EPC STORMWATER REVIEW COMMENTS
IN ORANGE BOXES WITH BLACK TEXT

STORMWATER MANAGEMENT PLAN (SWMP)

FOR
FLYING HORSE NORTH FILING NO. 4
SE OF SANDBAGGER DR & OLD STAGECOACH RD
UNINCORPORATED EL PASO COUNTY, CO 80908

EC-2

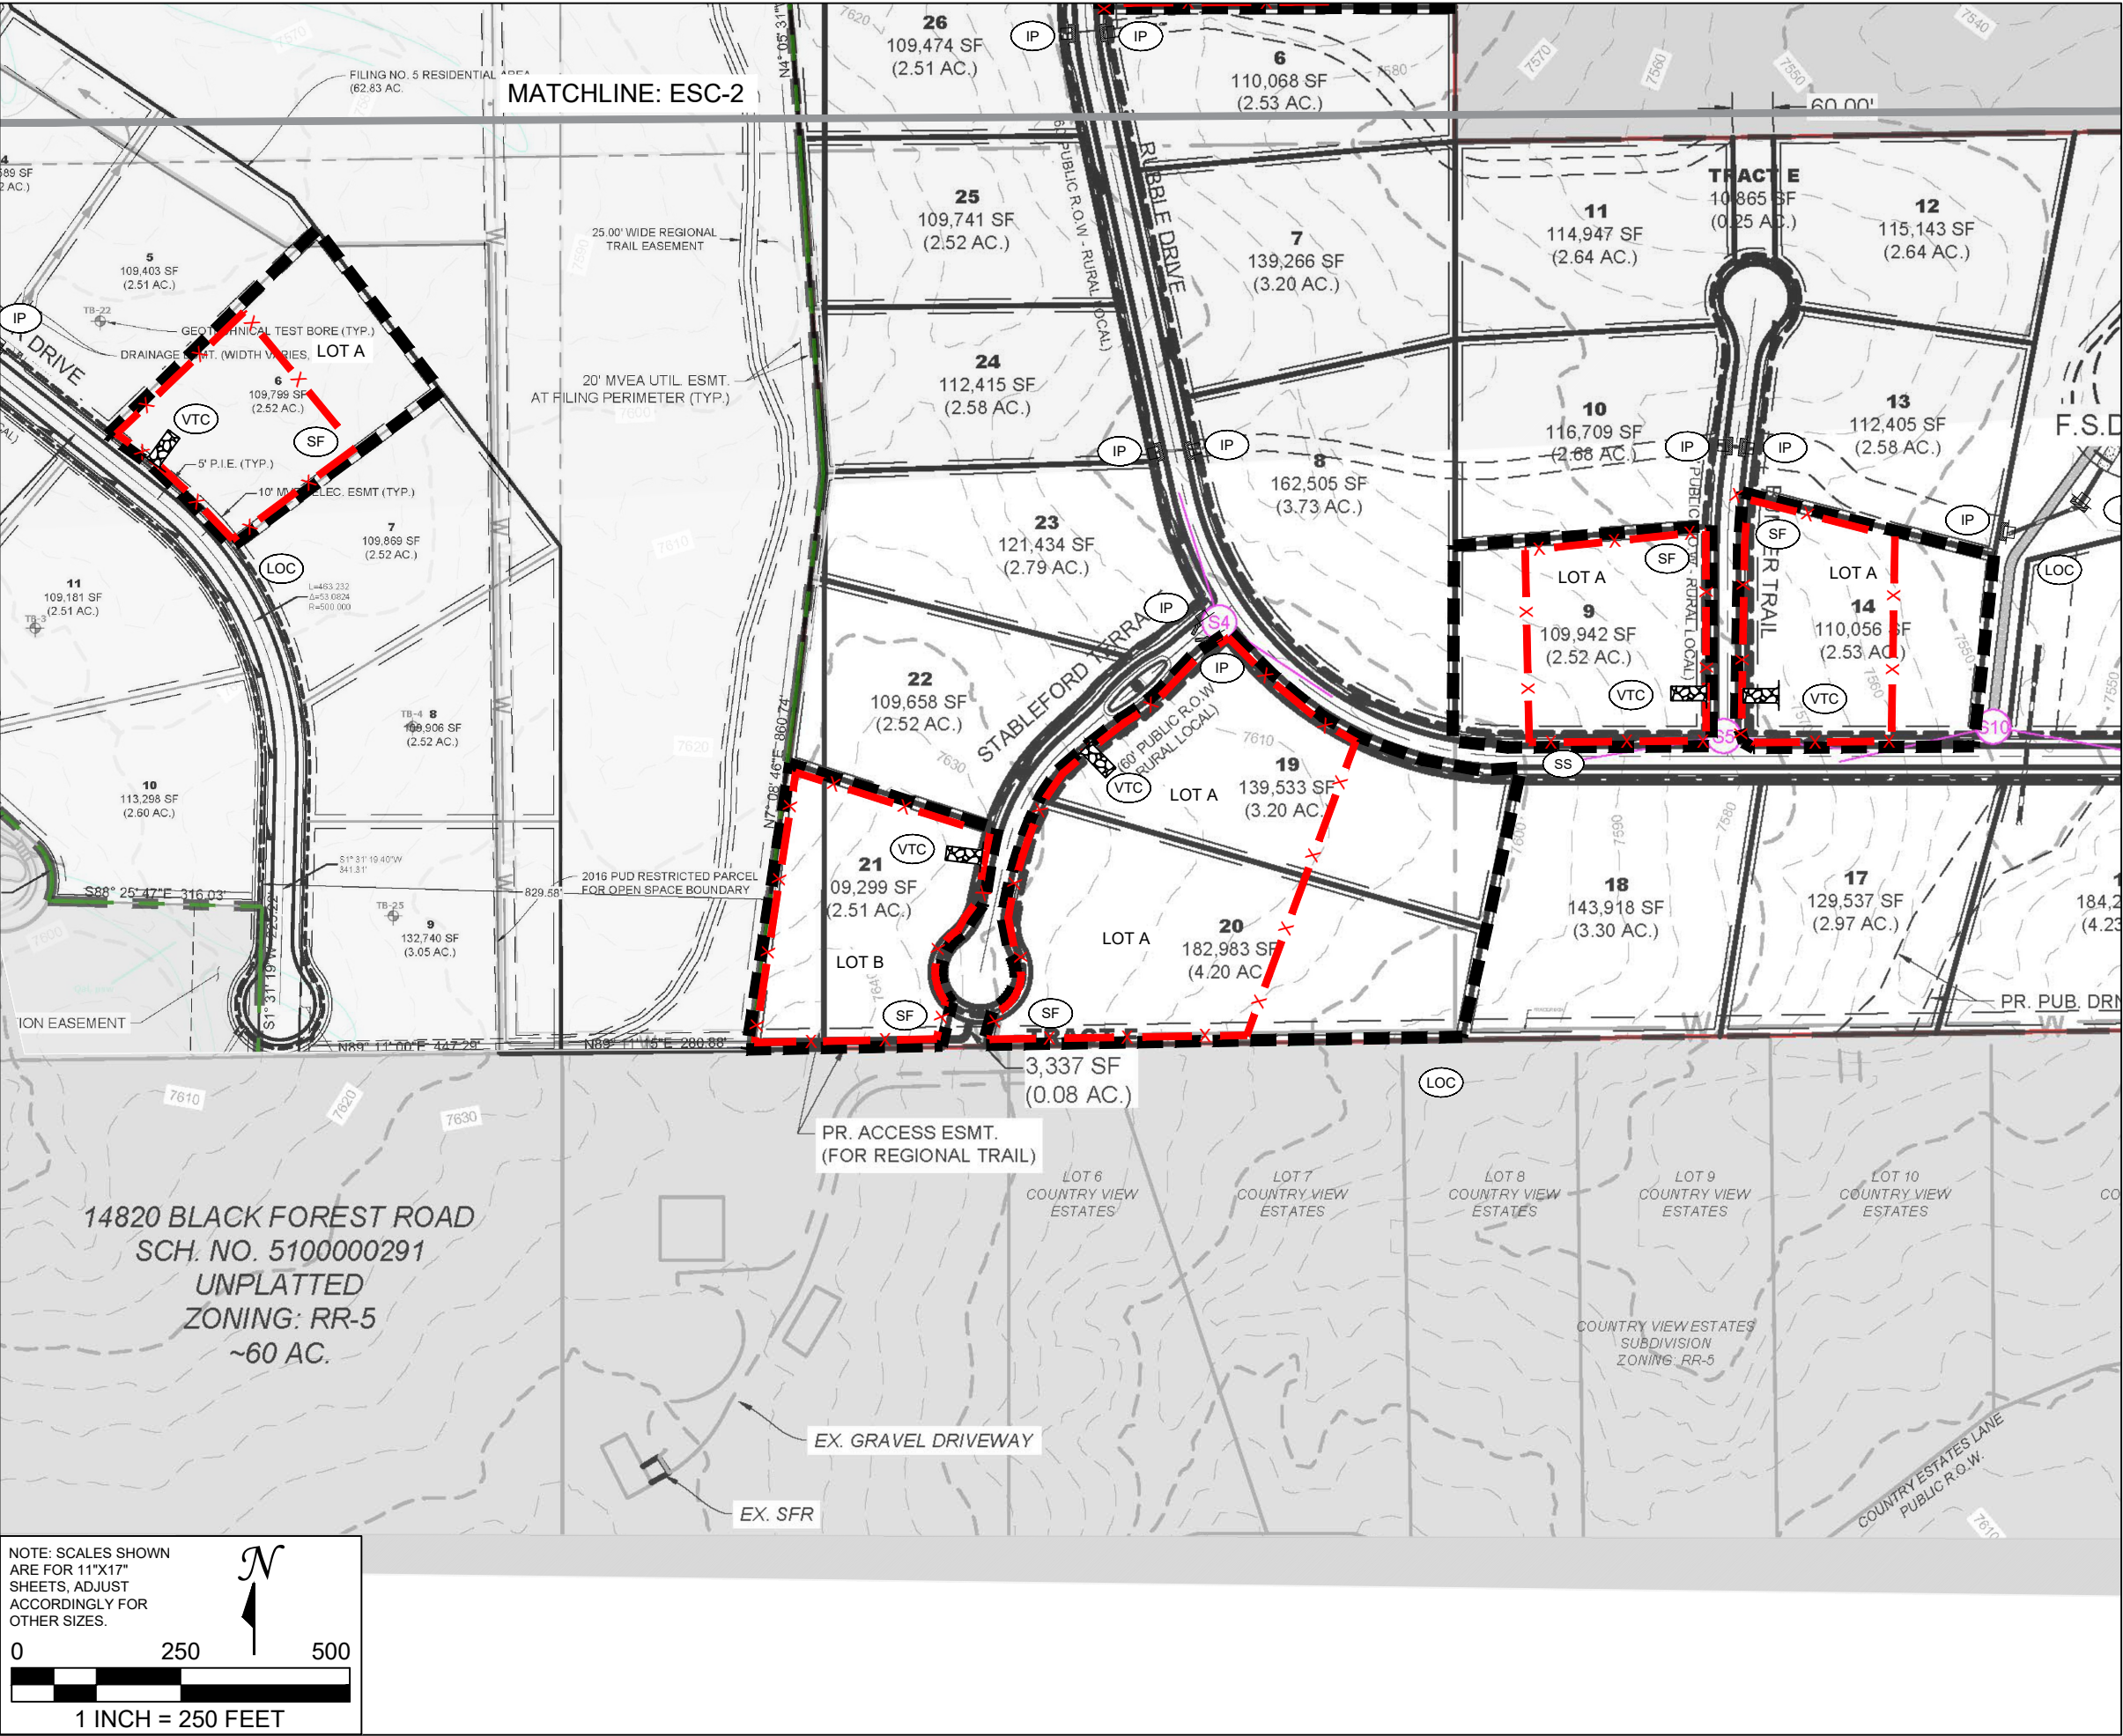
Flying Horse Filings 4 and 5 have lot imperviousness restrictions because the developer chose to utilize the Large Lot Exclusion for water quality which restricts lot imperviousness to 10% or between 10-20% imperviousness with an additional study. Many of these site plans are reporting impervious cover greater than 10% which would trigger the study requirement. I have comments on the reported square footage so please with the next submittal verify all impervious percentages reported. If lots have between 10-20% imperviousness an additional study will be required. Lots cannot be greater than 20% impervious without providing water quality.

I'm measuring closer to 9 which would be approximately imperviousness. Verify.

I'm measuring closer to 9,500 sqft which would be approximately 9% imperviousness. Verify.

I'm measuring closer to 9 which would be approximately imperviousness. Verify.
